From: Simon Davis
Sent: 10 November 2020 16:13
To: Planning Scanning
Subject: FW: Land at Stakers Farm, Yapton - Y/71/20/RES & Y/72/20/RES

From: Laura Gibbons <Laura.Gibbons@arun.gov.uk>
Sent: 10 November 2020 15:25
To: Arek Kadlec [REDACTED]
Cc: Paul Cann <Paul.Cann@arun.gov.uk>; Chris Harrison [REDACTED]; Christian O'Brien [REDACTED]; Brian Chamberlain [REDACTED]; Jonathan Merrick [REDACTED]; Scott Webster [REDACTED]; Simon Davis <Simon.Davis@arun.gov.uk>
Subject: RE: Land at Stakers Farm, Yapton - Y/71/20/RES & Y/72/20/RES

Subject: Land at Stakers Farm, Yapton - Y/71/20/RES & Y/72/20/RES

Odyssey		Page 1
Tuscany House	NORTH END ROAD	
White Hart Lane	YAPTON	
Basingstoke RG21 4AF	70 UNITS	
Date 26/07/2020 21:53	Designed by AK	
File 19-156 70 Units	Checked by	
Micro Drainage		Network 2020.1

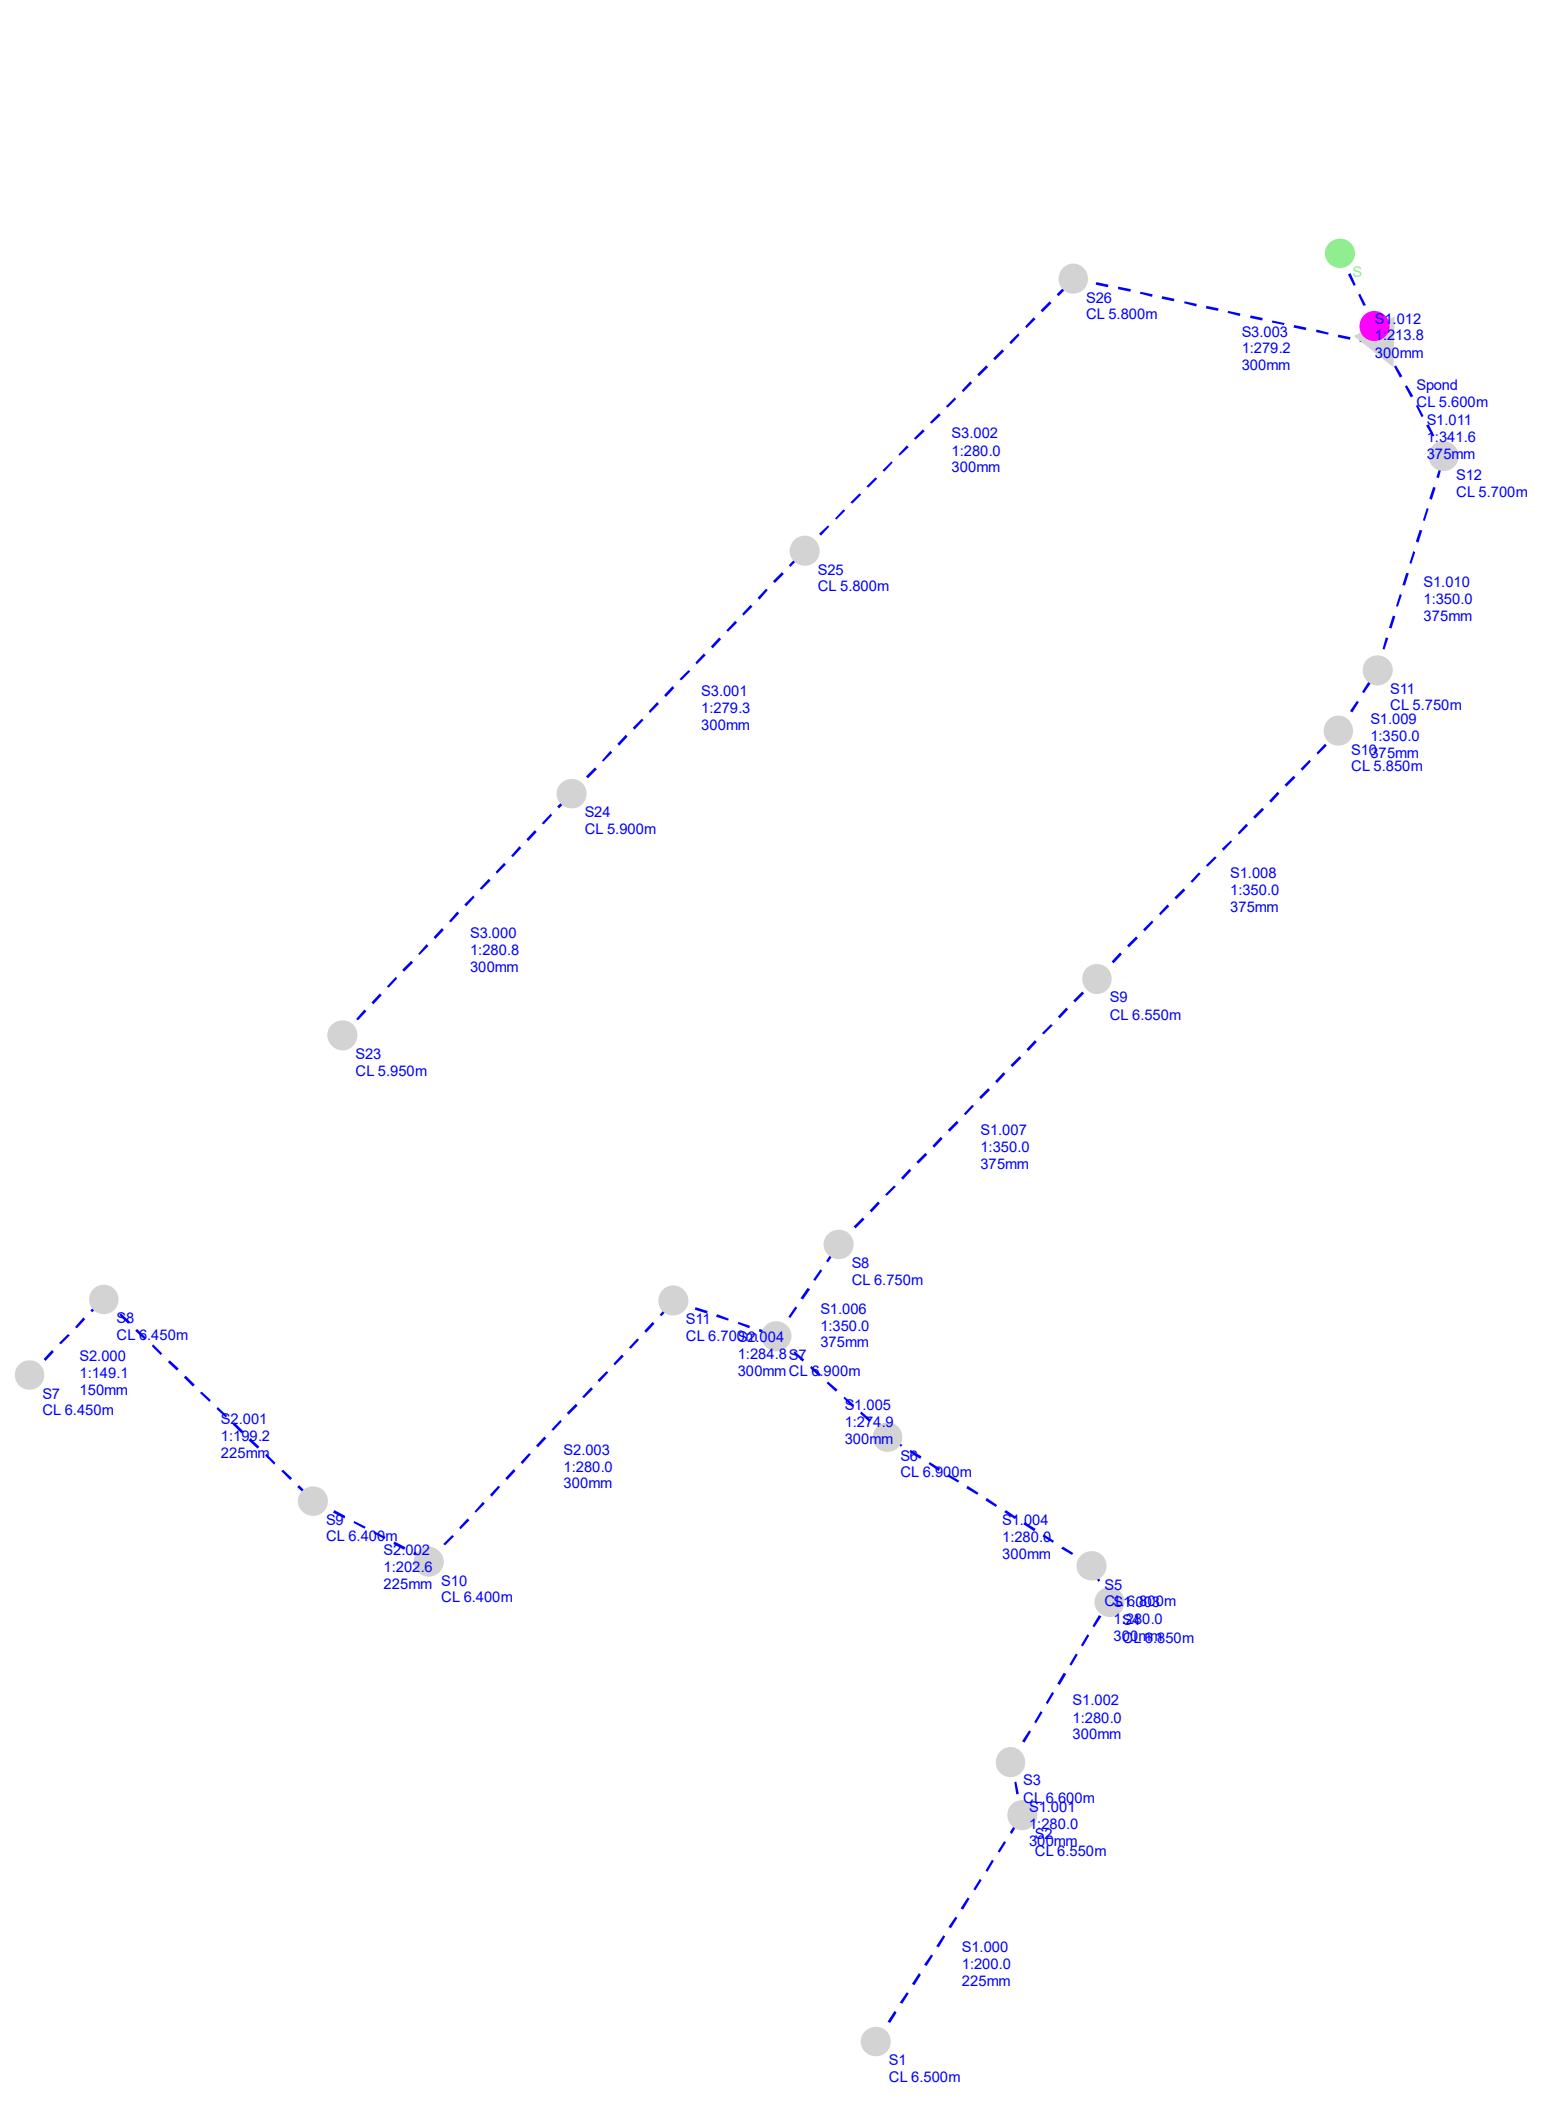
- All structures half draining within 24 hours for the 1 in 10 year plus 40% climate change event.
- All pipes achieving 1m/s full bore velocity.
- All infiltrating devices must cater for the 1 in 10 year storm between the invert of the entry pipe to the soakaway, and the base of the structure.
- All SuDS features must be located outside of the utilisable open space. The LAP must not be within the basin. This is supported by the below text in blue.
- Adequate freeboard must be provided on open SuDS features.

- Your comment *"A half drain time of less than 1440minutes must be provided for the 1 in 10 year plus climate change event, with urban creep allowance. This does not appear to be being achieved"*. As per Paul's e-mail we have used climate change to assess the 'no flooding' scenario for the 1 in 100 yrs event but designed for half drain on 1 in 10 year without climate change, as is the norm

- Your comment *"Half drain time results for lesser events for the permeable paving network must be provided."* We understand that this comment comes from the wish to half-drain the calculated storage within 24 hours to provide sufficient storage for a subsequent storm. Whilst the majority of the permeable paving system drains its half-volume within the 24 hours for the design storm of 1 in 10 yrs 48 hours duration (which is a suggested storm duration in CIRA C753 document, section 24.2.3 "Rainfall to be used in calculations" and "Design rainfall" sub-section) few sections exceeded the 24 hour time period. We have however catered for such instance and provided sufficient storage within the system and a volume of the subsequent 1 in 10 yrs storm

can be accommodated within permeable paving without surface flooding. Please see below the snapshots from the Microdrainage model results that shows required storage for the 1 in 10 yrs storm event and storage achieved in the system for the 1 in 100 yrs with climate change event – this shows that the storage for the 100 yrs event is twice the storage required for the 1 in 10 yrs thus mimicking the overall principle behind half-emptyingtime.
